PRELIMINARY DRAINAGE REPORT

ROLLIN RIDGE ESTATES

April 30, 2018

JPS Project No. 081702
PCD File No.: SP-18-001

FLOODPLAIN MAP

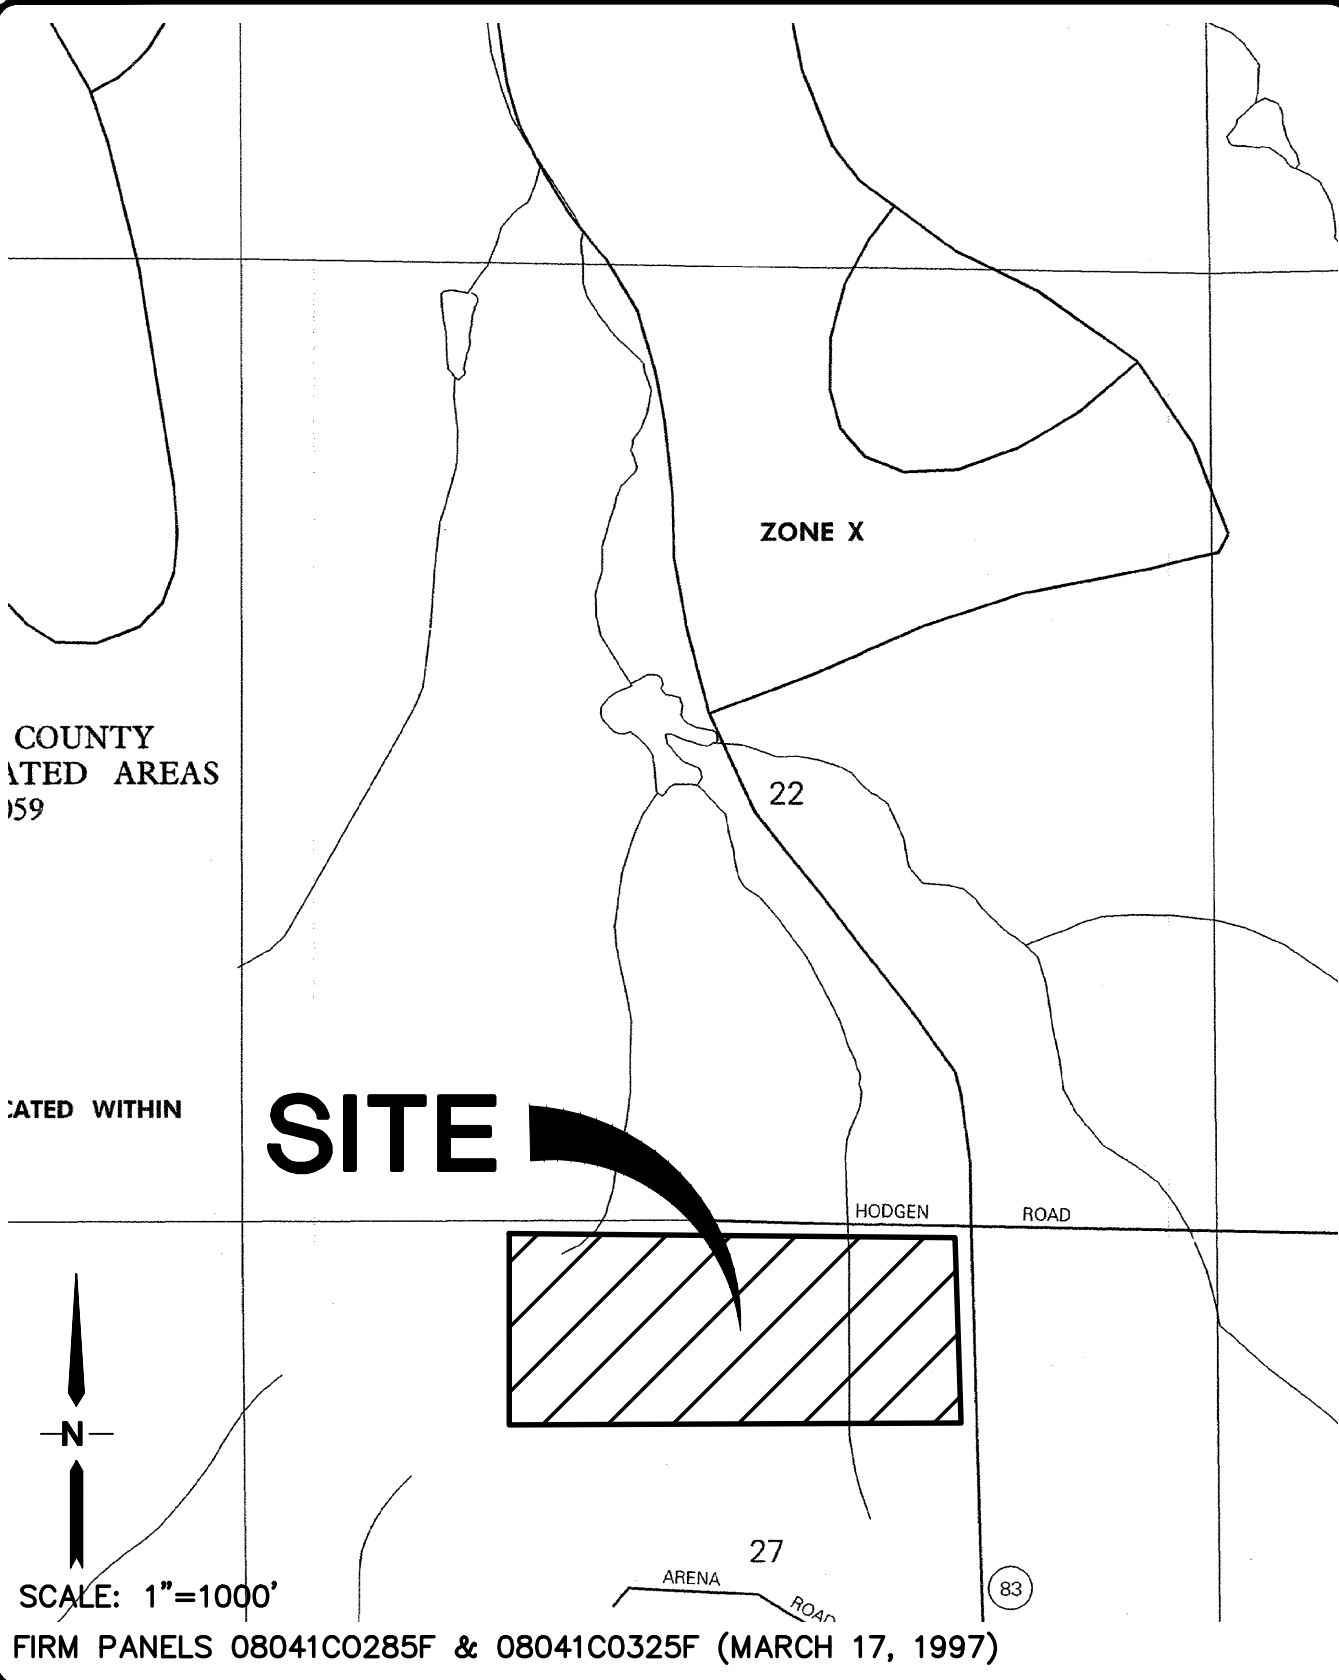
↑
please confirm,
appears incorrect.
